**KIRKLEES METROPOLITAN COUNCIL
INVESTMENT & REGENERATION SERVICE**

**DELEGATED DECISION TO DETERMINE APPLICATIONS FOR
CONSENT, AGREEMENT OR APPROVAL REQUIRED BY CONDITION**

Reference No:	2025/44/92535/W
Site Address:	Part of former St Luke's Hospital site, Blackmoorfoot Road, Crosland Moor, Huddersfield, HD4 5RA
Description:	Discharge of details reserved by conditions 9 (temporary drainage), 14 (oil/petrol interceptor), 15 (flood routing), 16, (drainage strategy), 19 (landscaping) on previous permission 2023/91405 for erection of foodstore (Class E) with associated access, parking, servicing area and landscaping
Recommending Officer:	Ellie Thornhill

Officer report

Client	LiDL						
Project	Proposed LiDL Foodstore Crosland Moor						
Drawing title	Drainage Strategy						
Drawn	JS	Chkd	RT	Date	August 2022	Scale	As Shown
Sheet Size	A1	Drawing No.	21561-DR-C-0100	Revision			P7

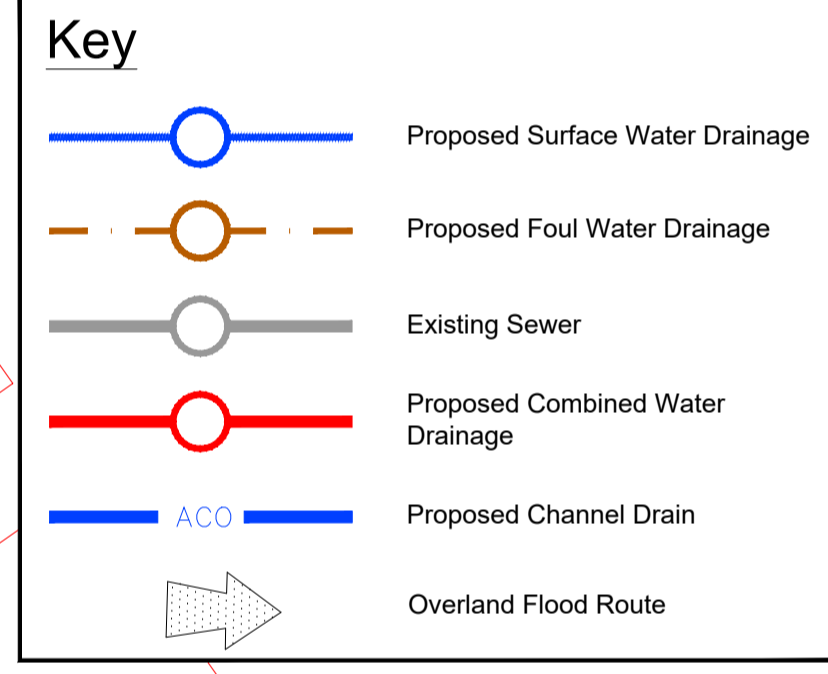
The condition states that, “The scheme shall include a risk assessment and method statement, in accordance with CDM Regulations 2015, for access to and into the attenuation structure, and the scheme shall include a maintenance and management plan for surface water infrastructure.” This has not been included in the submission.

“Maintenance and Management plans need to be bespoke to the site and the tank design selected. The plan should reflect a risk assessment and suitable method statement under CDM Regs 2015 for a facility to be completed and handed over. This included methodology and scheduling of individual tasks, i.e. how you are going to do this, not just what you aim to do.

How is the tank to be accessed for inspection? Where is the pump to be used? The penstock is likely to need greasing to ensure parts do not seize up.

Sumps will need clearing in a flow control device manhole.

When a flow control device is moved we recommend to replace the neoprene seal.

A plan and cross section of the tank has not been provided.

A drawing showing contributing areas to each individual surface water sewer leg has not been produced as requested.

The problems of connecting crate storage to a combined sewers has not been addressed.

Design life has to be guaranteed or independently tested, e.g. BBA certificate.
